ADC PARKS & GREENSPACE ARBORICULTURE

PLANNING APPLICATION: LU/96/16/DOC

ADDRESS: Land North of Toddington Lane Littlehampton BN17

BRIEF DESCRIPTION: Application for approval of matters reserved by conditions imposed under LU/47/11/ (units 6-117) relating to conditions 5 for details of materials & external finishes, 7 appearance, landscaping & layout particulars, 10 Surface Water Drainage Scheme, 11 access to & maintenance of watercourse or culver, 12 discharge of any flows to watercourses or culverting, diversion, infilling or obstruction of any watercourse , 13 Foul Drainage System, 14 landscape & layout particulars, 15 tree protection, 22 Construction Method Statement, 23 details of construction compound, 24 piling or any foundation designs, 25 vehicle cleaning facilities, 26 layout & specifications & construction programme, 30 fire hydrants & 31 details of & timetable for decentralised & renewable energy sources.

Tree Removal and Tree Protection Proposals

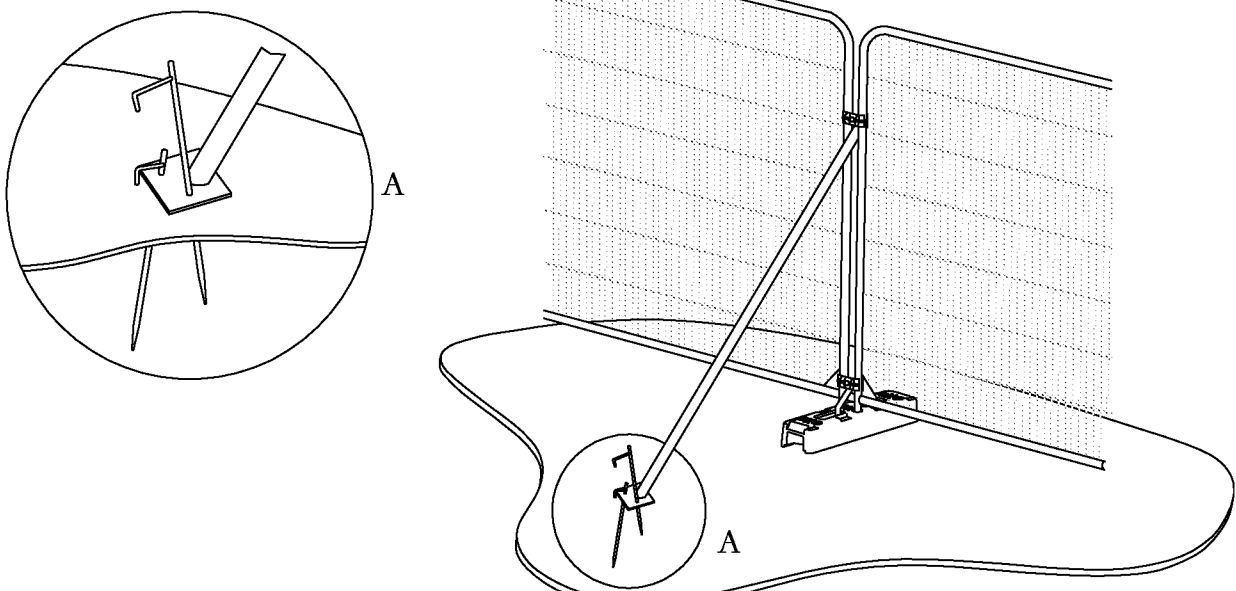
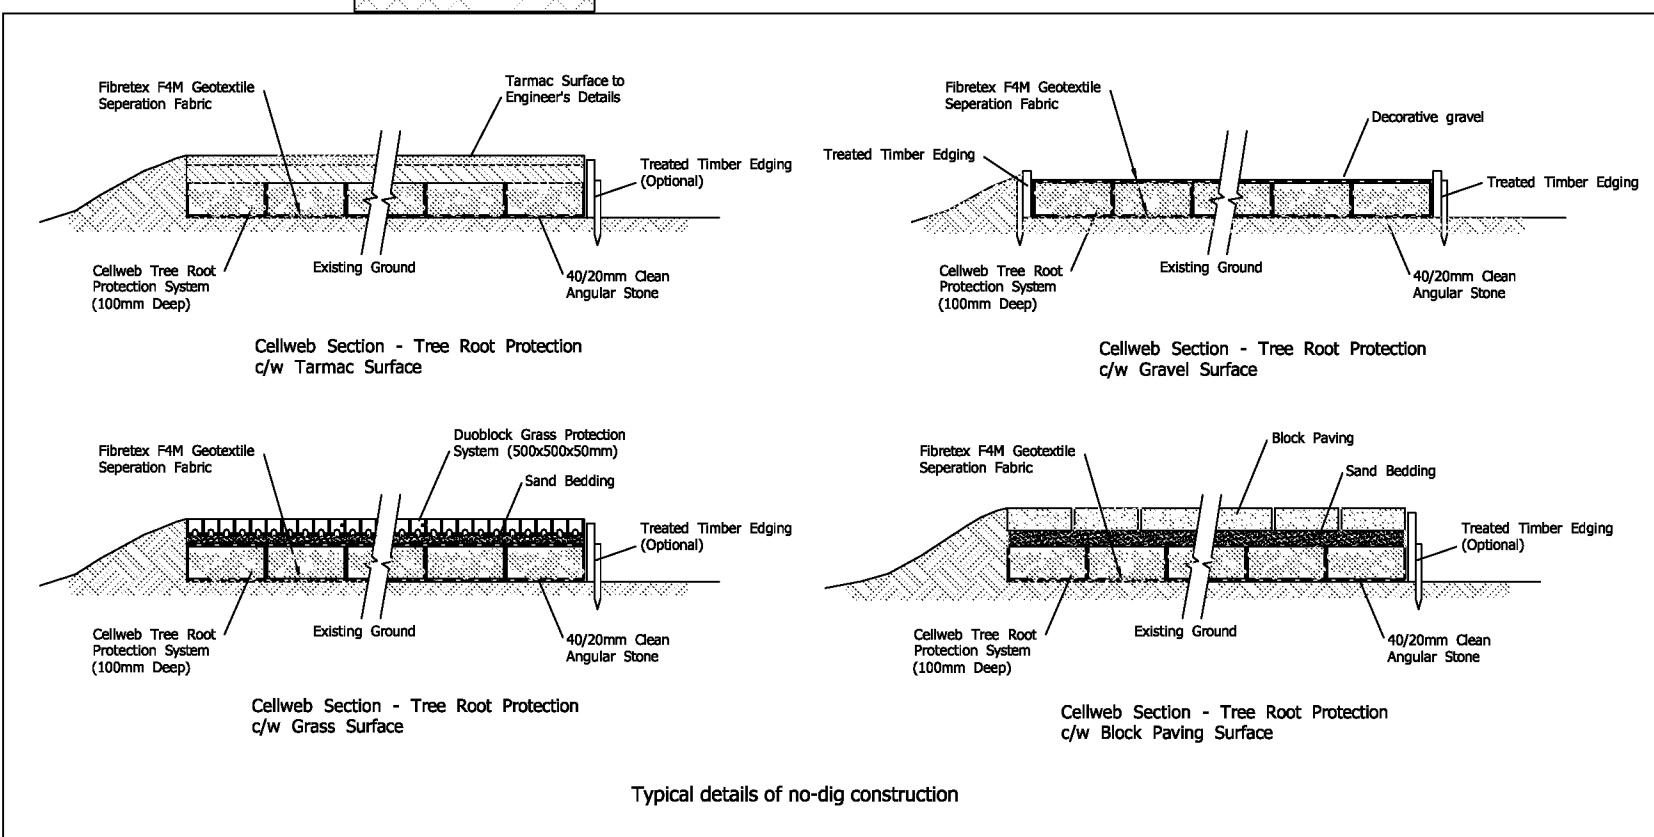
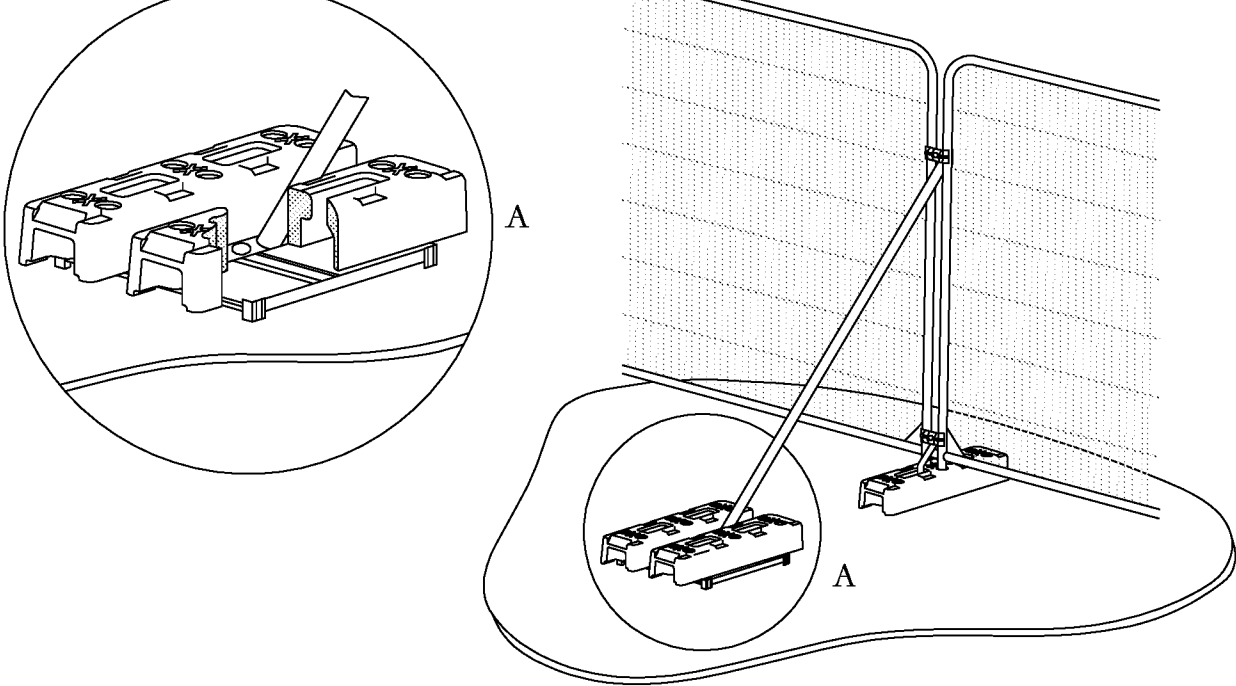
- This application relates to tree protection conditions (15) *imposed under LU/47/11/*.
- From the site assessment it is evident that T183 and T182 (earmarked for removal) have already been removed and development is now underway in this area.
- The applicant has outlined the desire to locate the footprint of a proposed dwelling (unit 25) within the Root Protection Area of T1. The applicant has offered no method statement/mitigation measures on how this would be achieved in accordance with the BS 5837:2012 *Trees in relation to design, demolition and construction – Recommendations*.

- I would object to this application as the applicant has failed to offer a method statement for the proposed excavation for the foundations for unit 25, within the RPA of **T1**.
